MEMORANDUM

To: FILE
From: Richard Knowland
Subject: Application ID: 2014-079
Date: 6/17/2014

Memo To: Barbara Barhydt
Rick Knowland
From: David Margolis-Pineo
Public Services Staff
Re: Bayside Anchor – 81 East Oxford Street

BOUNDARY SURVEY AND LOT DIVISION
 OXFORD STREET & BOYD STREET, PORTLAND, MAINE
 MADE FOR
 PORTLAND HOUSING AUTHORITY

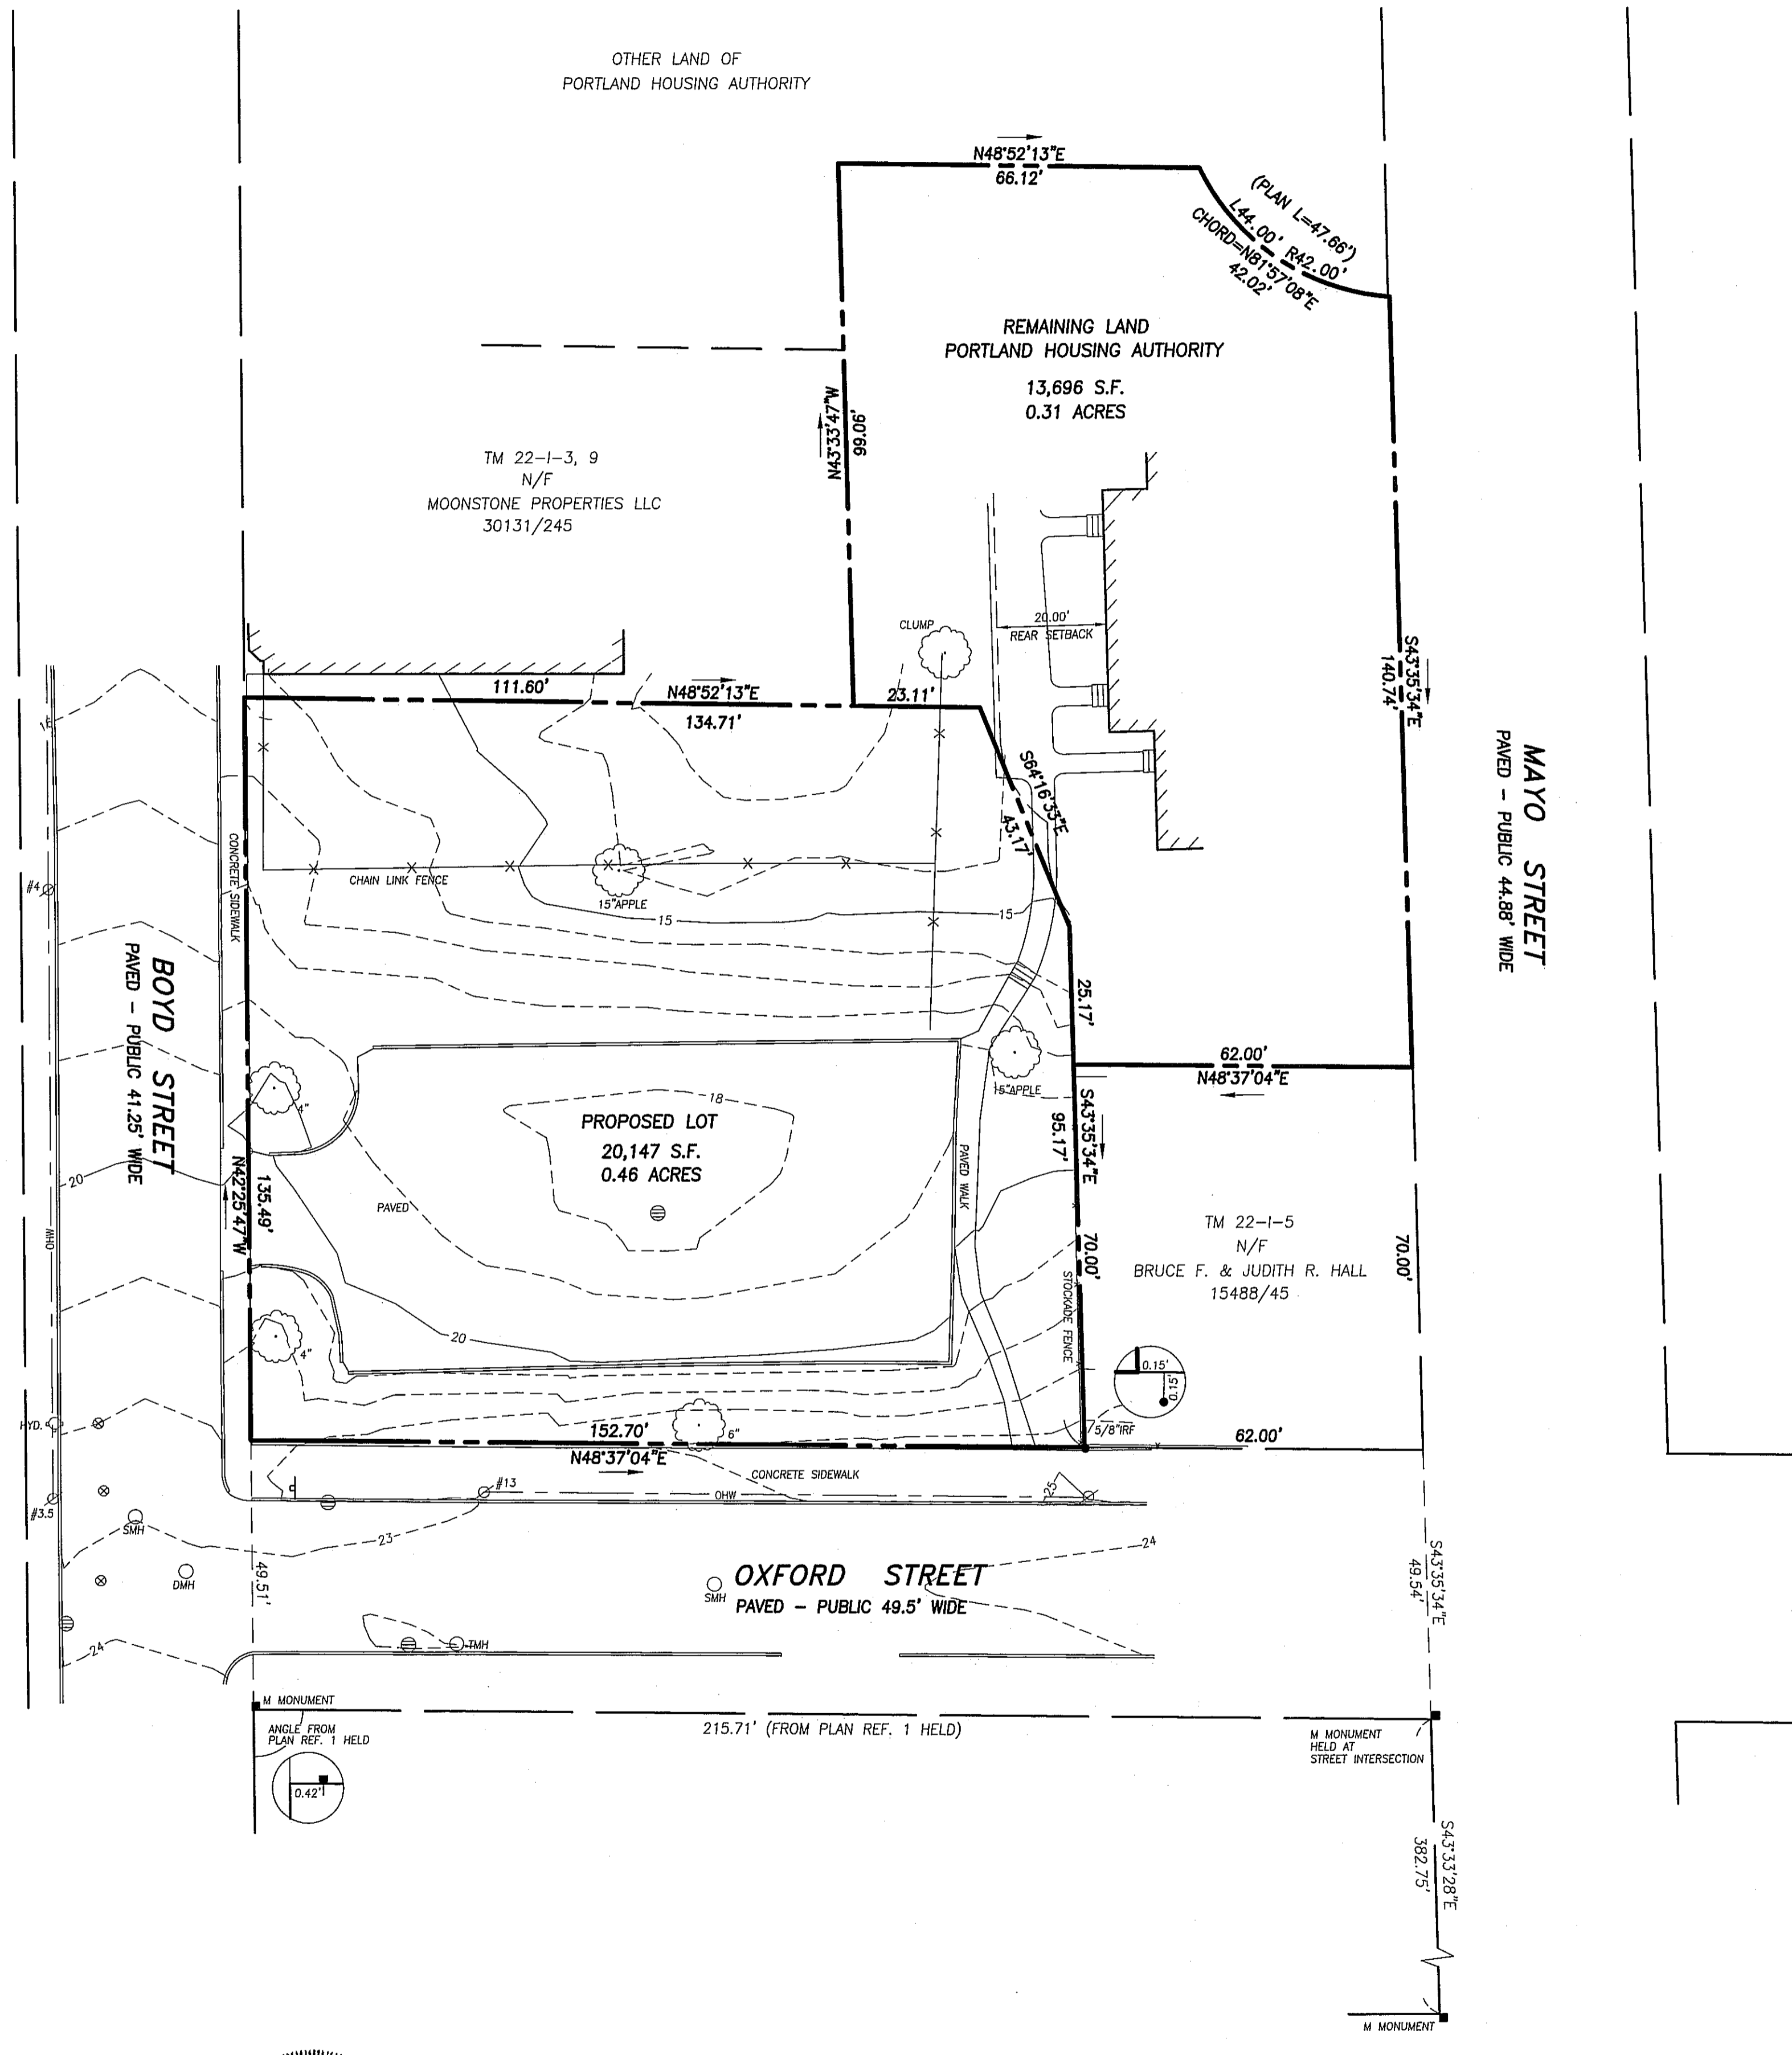
1. Survey plan fails to meet the submission requirement and is unacceptable. Please review requirements and resubmit.
2. There are several proposed encroachments into the road right of way which will require either easements or licenses.
3. Proposed street parking will need to be reviewed. Since Boyd St is approximately 29.5' wide and Oxford is approximately 27.5' wide, access for emergency vehicles may be an issue.
4. With the loss of 26 parking spaces and the need of 30 additional spaces, campus parking needs will be evaluated.
